RailCorp

28 April 2010

**MAJOR PROJECT APPLICATION – MIXED USE DEVELOPMENT - MP08_0112
7-9 Gibbons Street, Redfern**

DRAWING:
SECTION A-A
DRAWING No.:
DA - 1201
ISSUE:
C
JOB No.:
5414

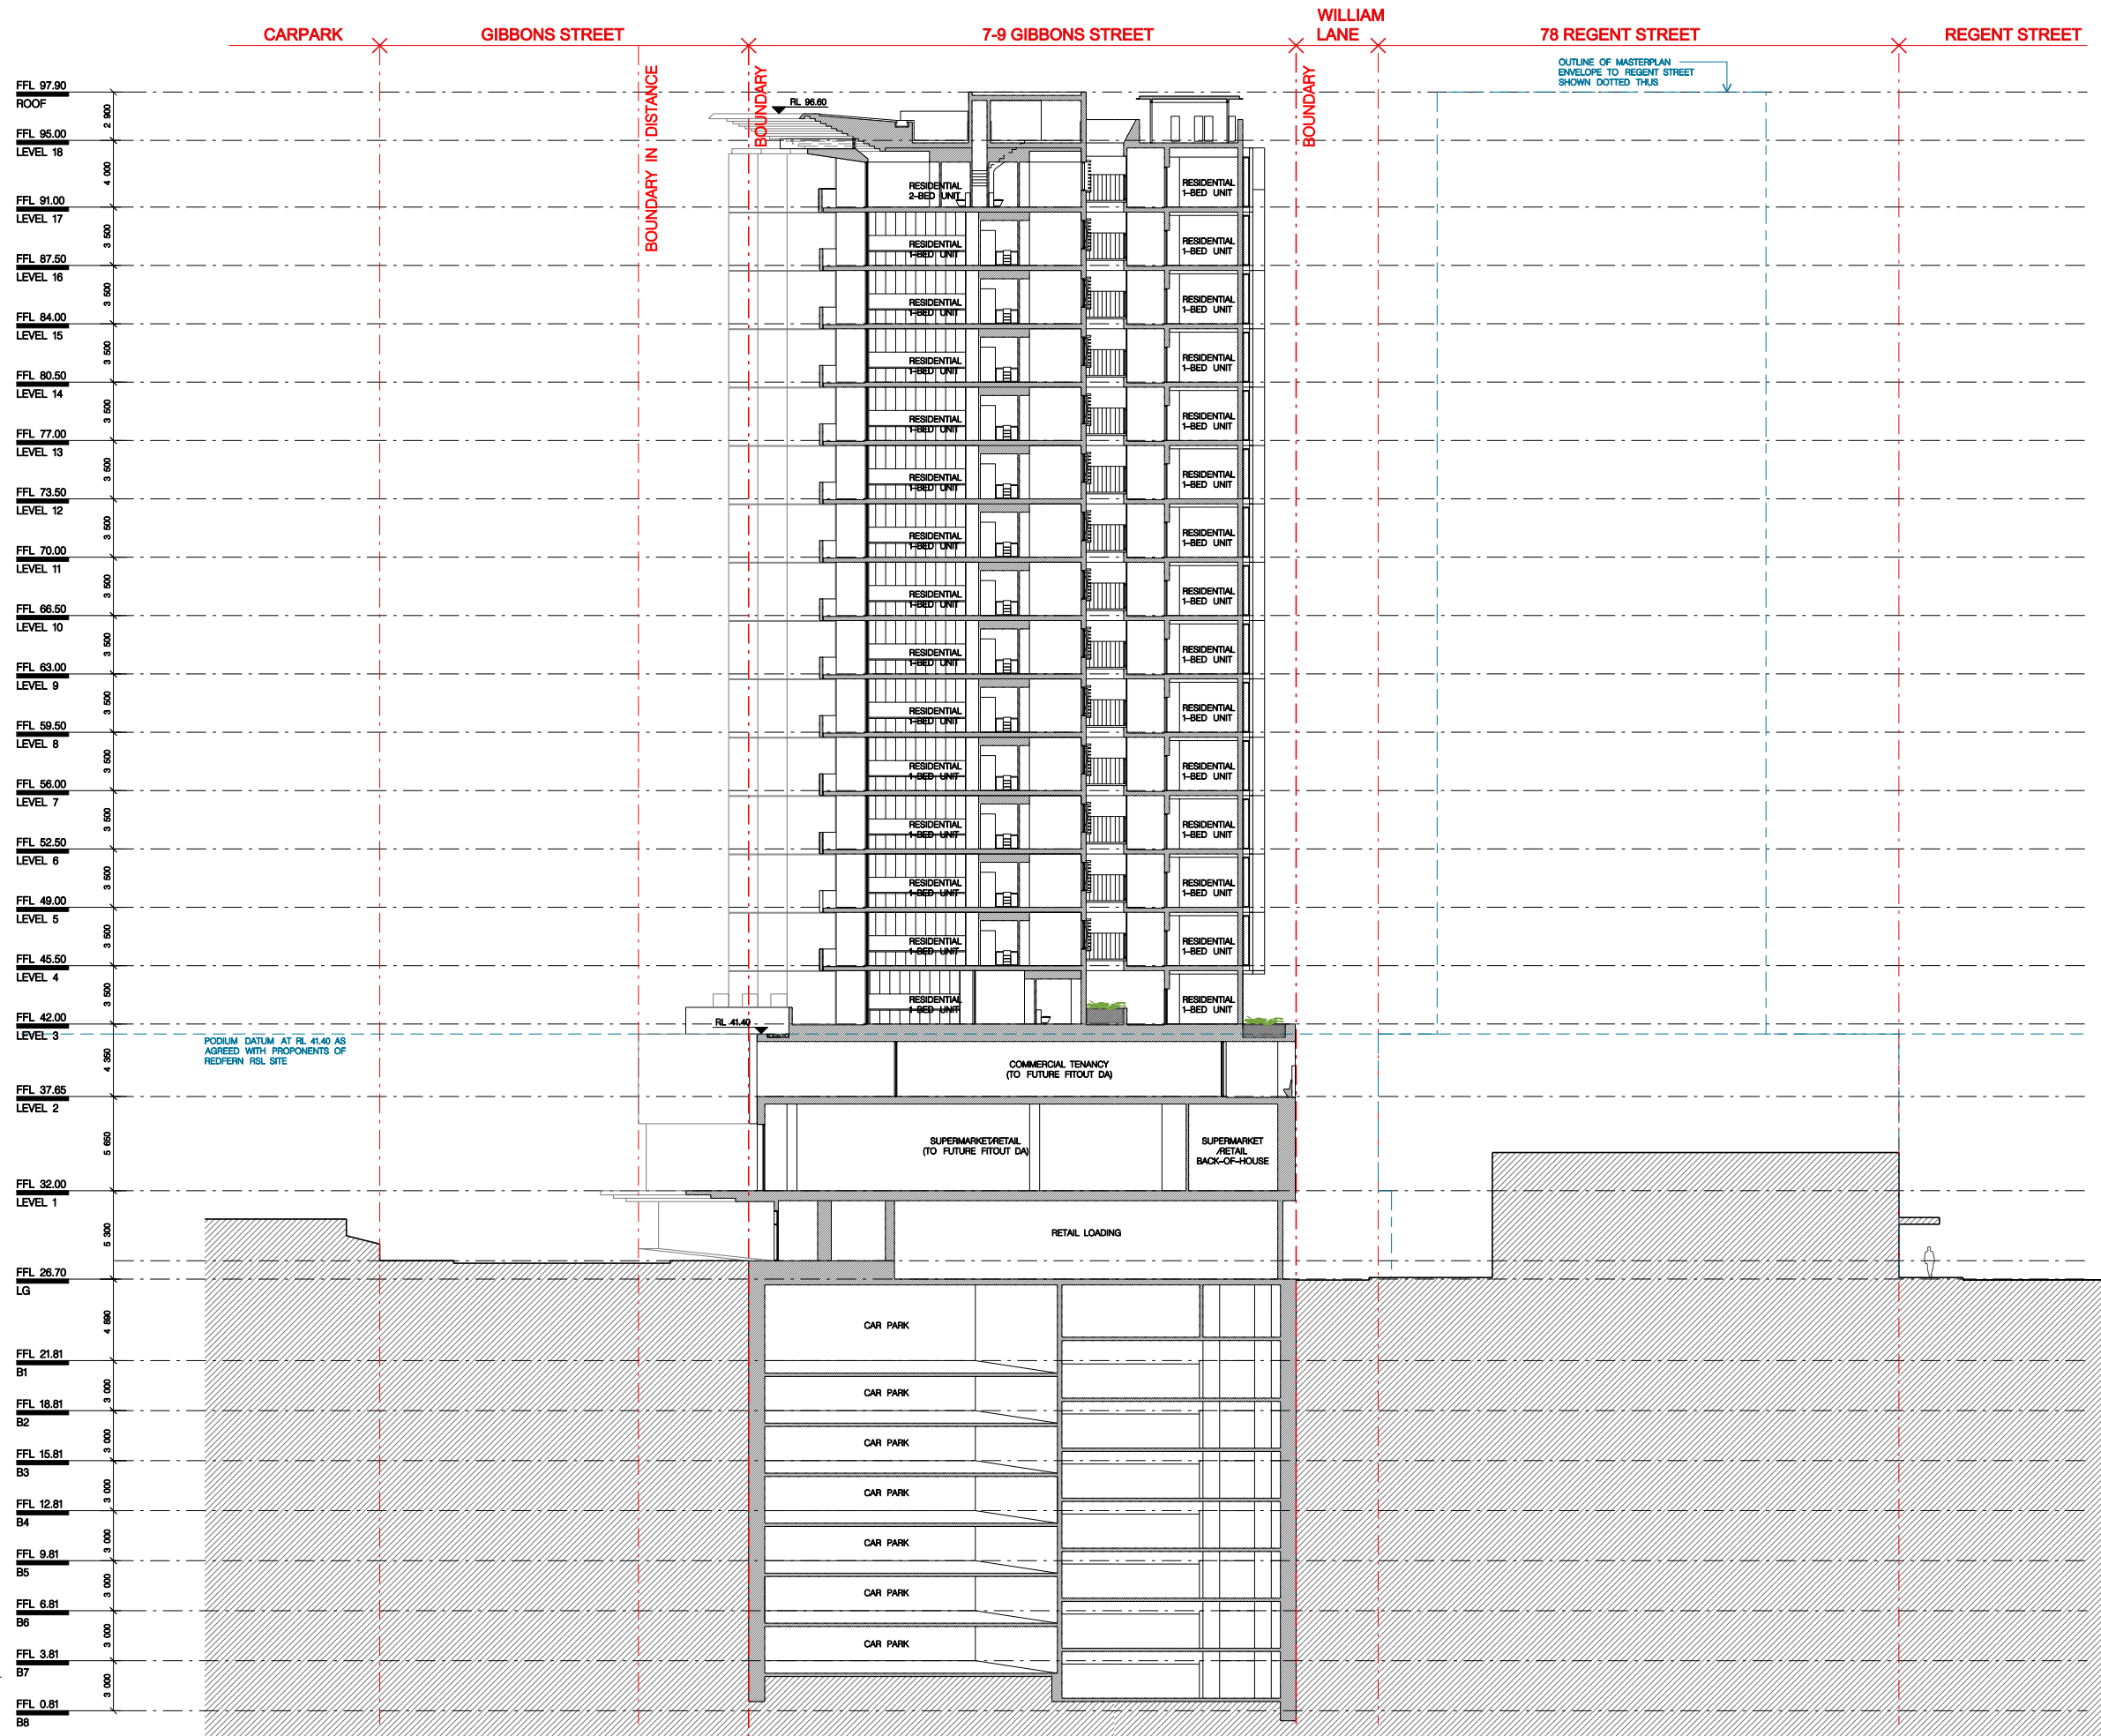
RailCorp notes that there are no drawings identifying the relationship of the proposed development with existing rail infrastructure either vertically or horizontally and most notably the Illawarra Relief tunnels. A reference within the Attachment 10 nominates drawings but these were not attached. It would seem from some of the written information provided that the site excavation will extend to well below the level of the tunnels and that soldier piles and anchors are proposed to be used for temporary support of the excavation. These factors will require very close and detailed scrutiny particularly if it is proposed to install anchors in the vicinity of the tunnel easement.
